**Consultation Response from Mike Hibbert,  
KC Waste Strategy( Refuse & Recycling)**

**2024/93026 land at, Manor Street, Newsome, Huddersfield, HD4 6NW**

**Discharge of details reserved by conditions 3 (materials), 5-9 (site contamination), 11 (external lighting), 12 (cycle parking), 13 (bin store), 14 (ecological design strategy), 15 (landscaping) and 16 (drainage) of previous permission 2022/90655 for erection of 10 student residential units with associated landscaping**

**Date Responded: 03/12/2024.  
Responding Officer: Mike Hibbert  
Responding Ref: WPS 24-080.**

DRAWING TITLE
SITE PLAN - PROPOSED

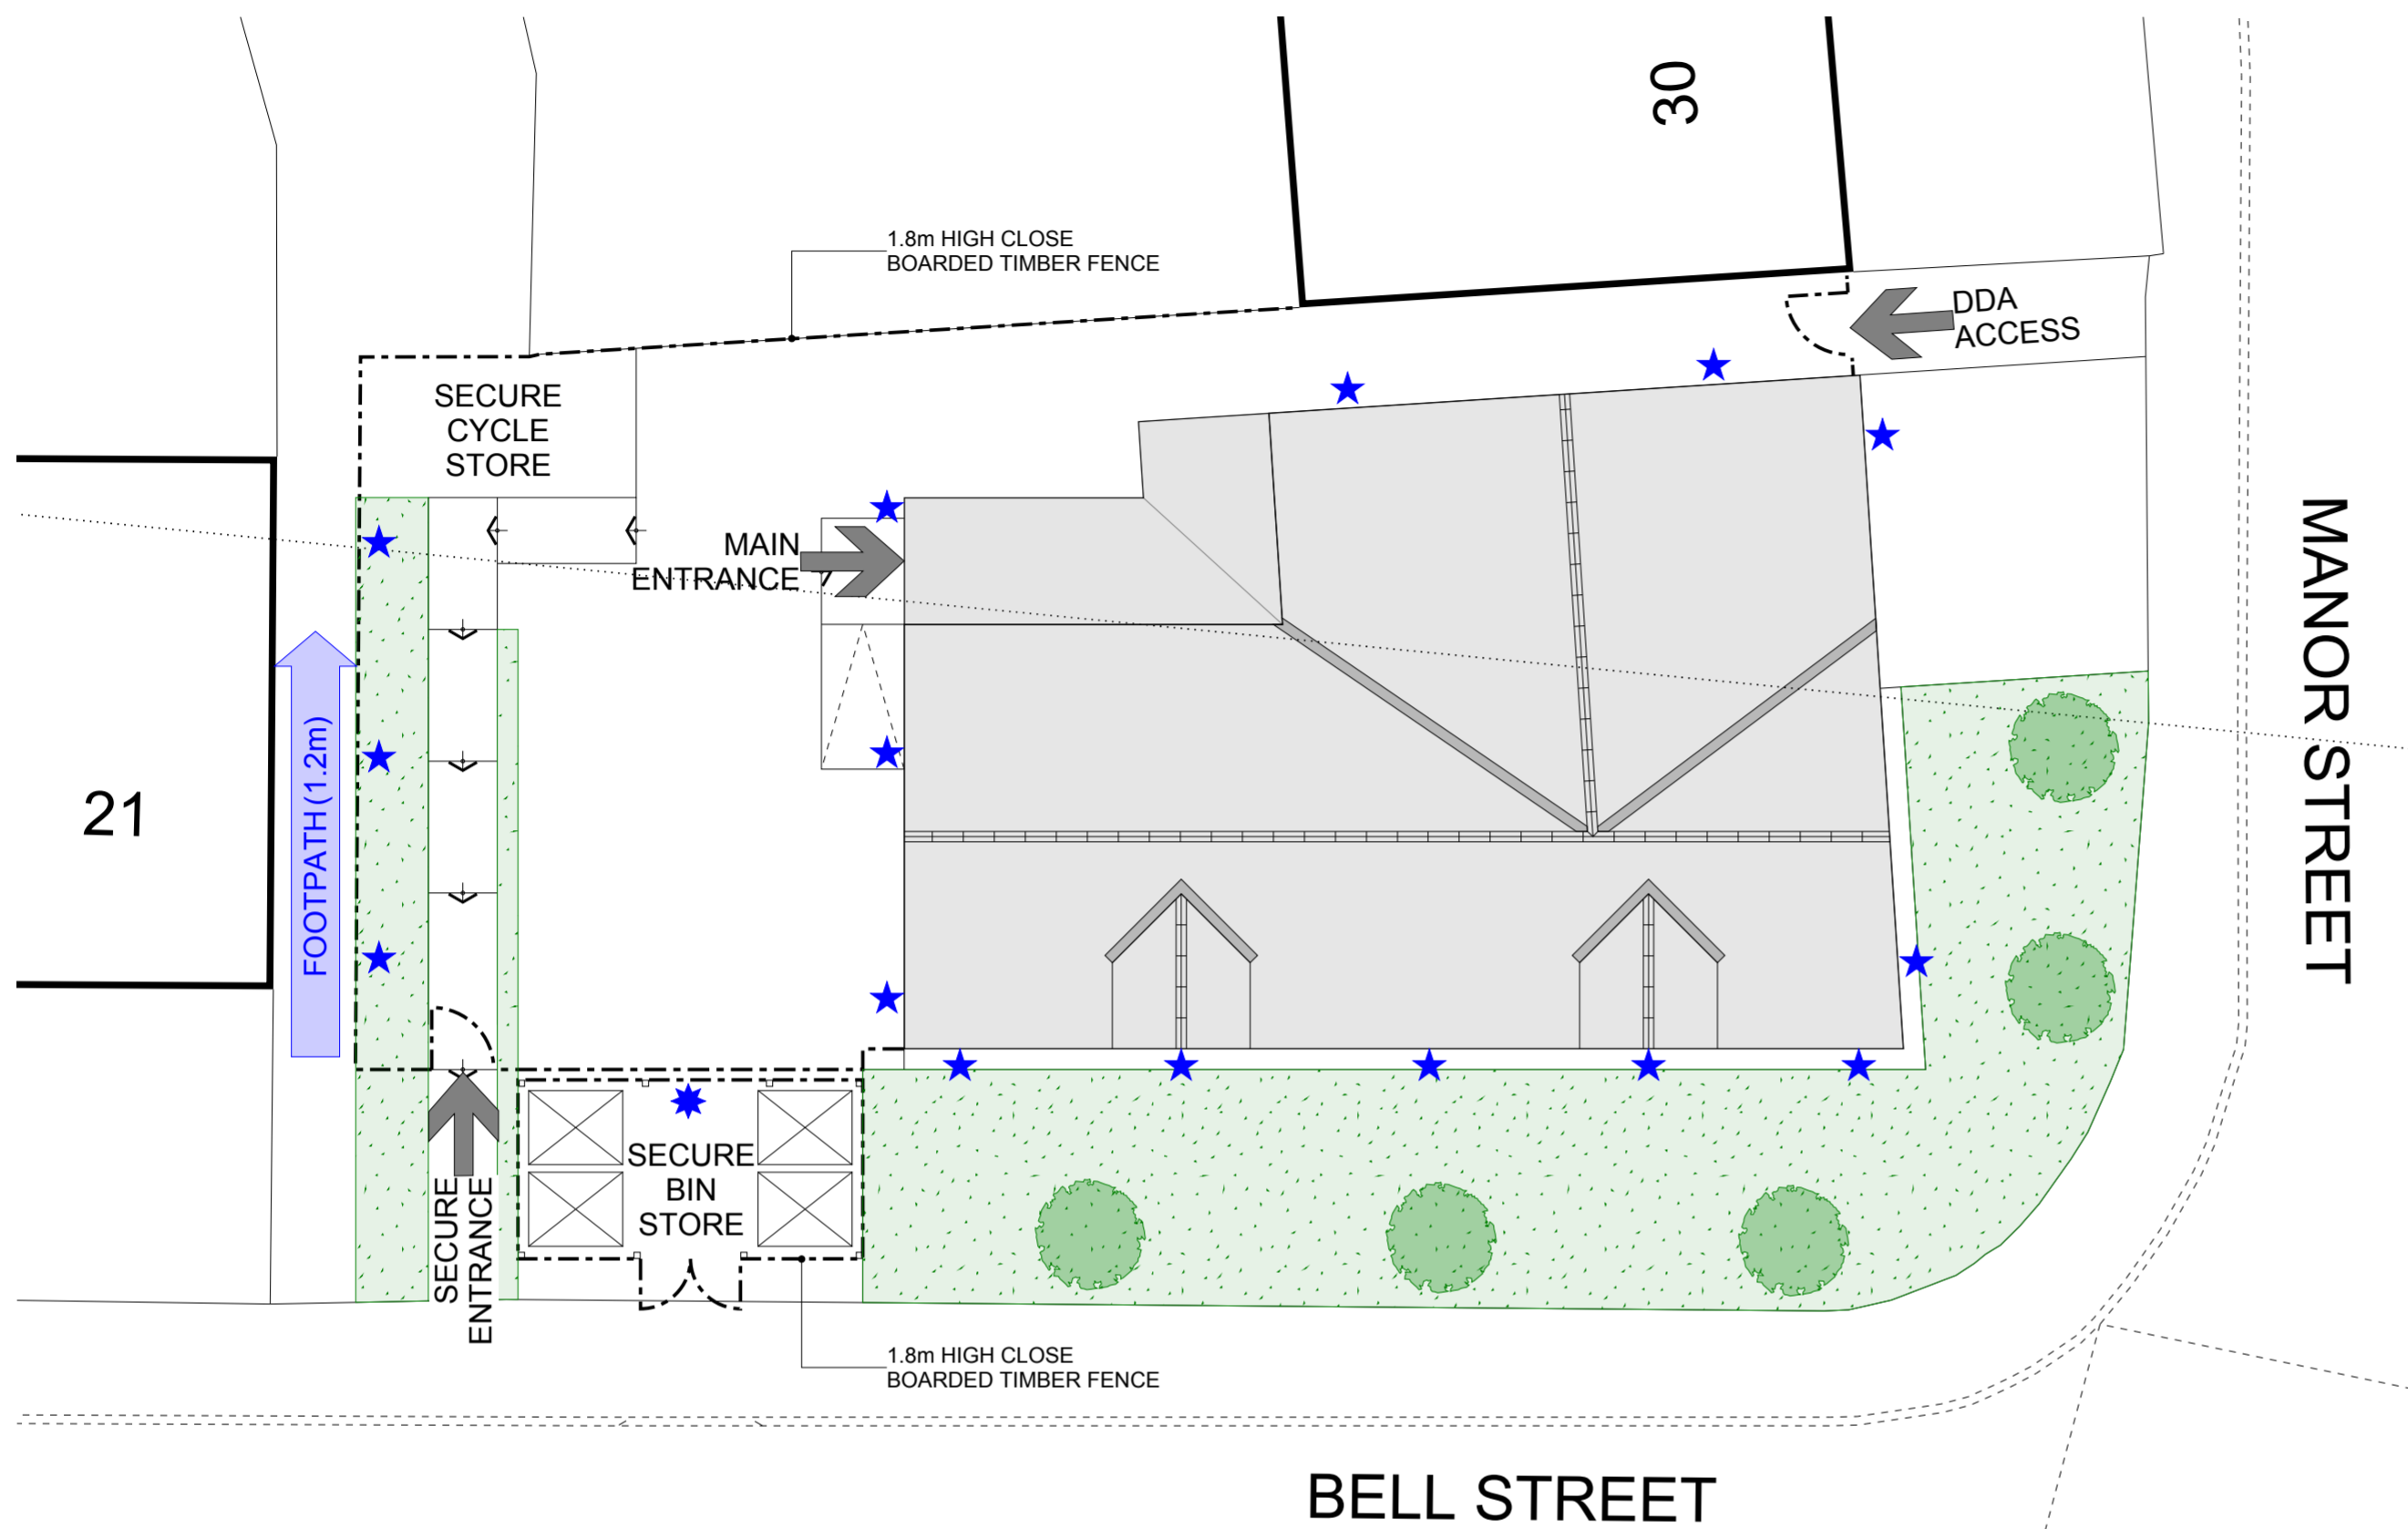
The applicant has submitted Site Plan – Proposed DRG No.21 dated 21.10.24 that is annotated to show the location of the Bin store on site.

- The WCA can confirm that the proposed arrangements are acceptable, and that Condition 13 can be discharged.
